From: [Keli Bender](#)
To: [Dusty Pilkington](#)
Subject: Re: LP-17-00007 Swauk Valley Ranch Revised Application
Date: Wednesday, January 24, 2018 8:54:08 AM

**SHEET 1**

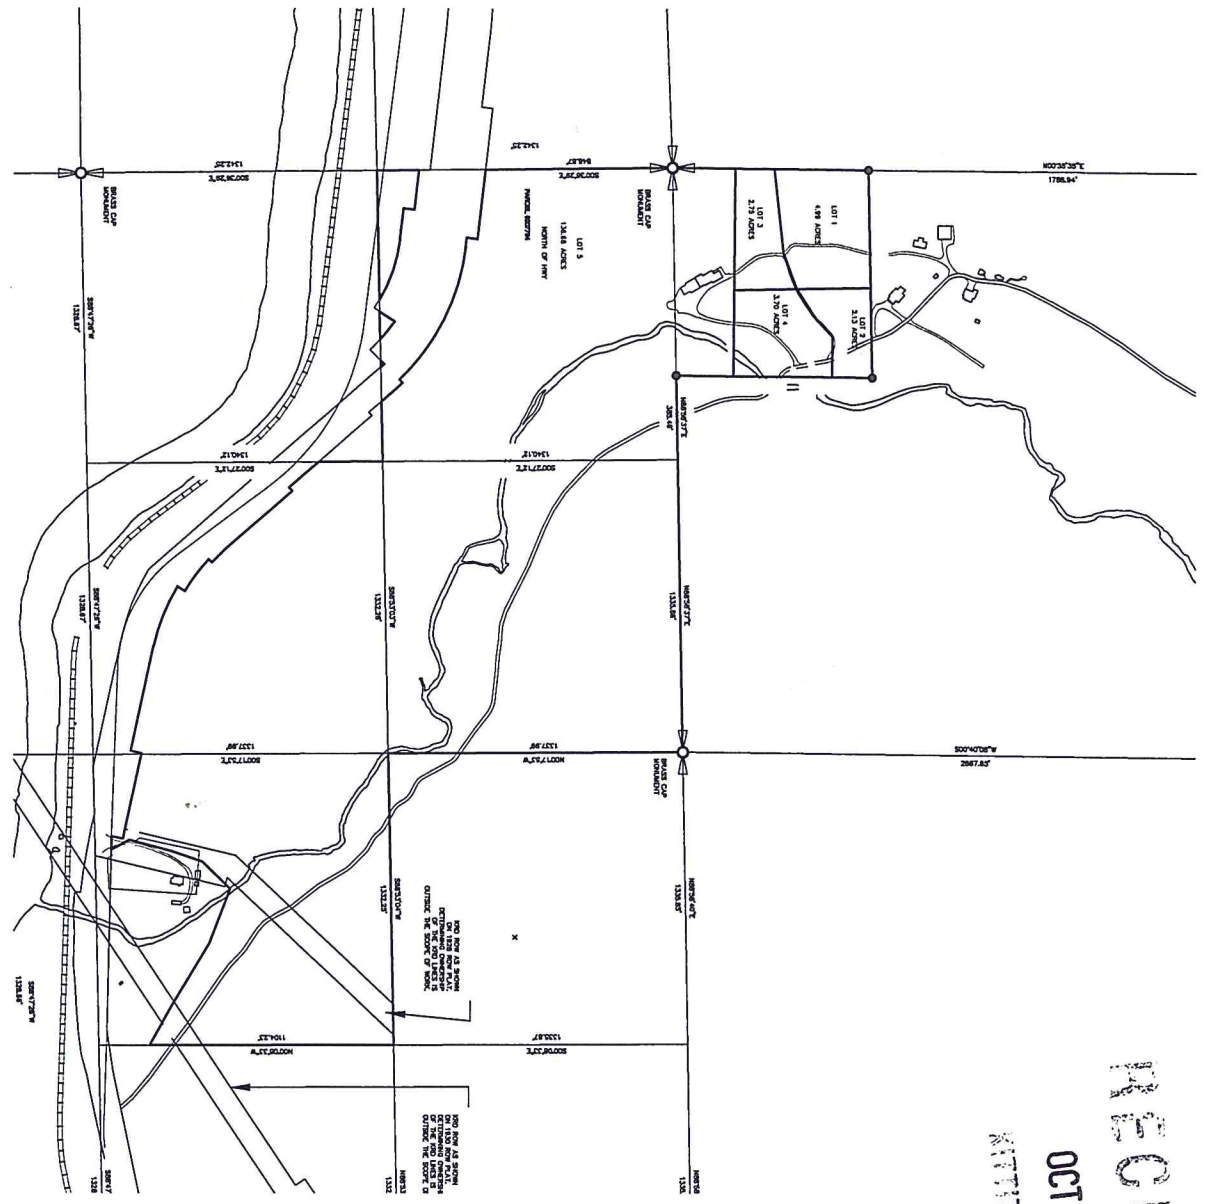
In regards to the Swauk Valley Ranch project, it appears that some of the lots are outside of the KRD service area. This will need to be address with the Landholder as well, prior to approval. Thank you.
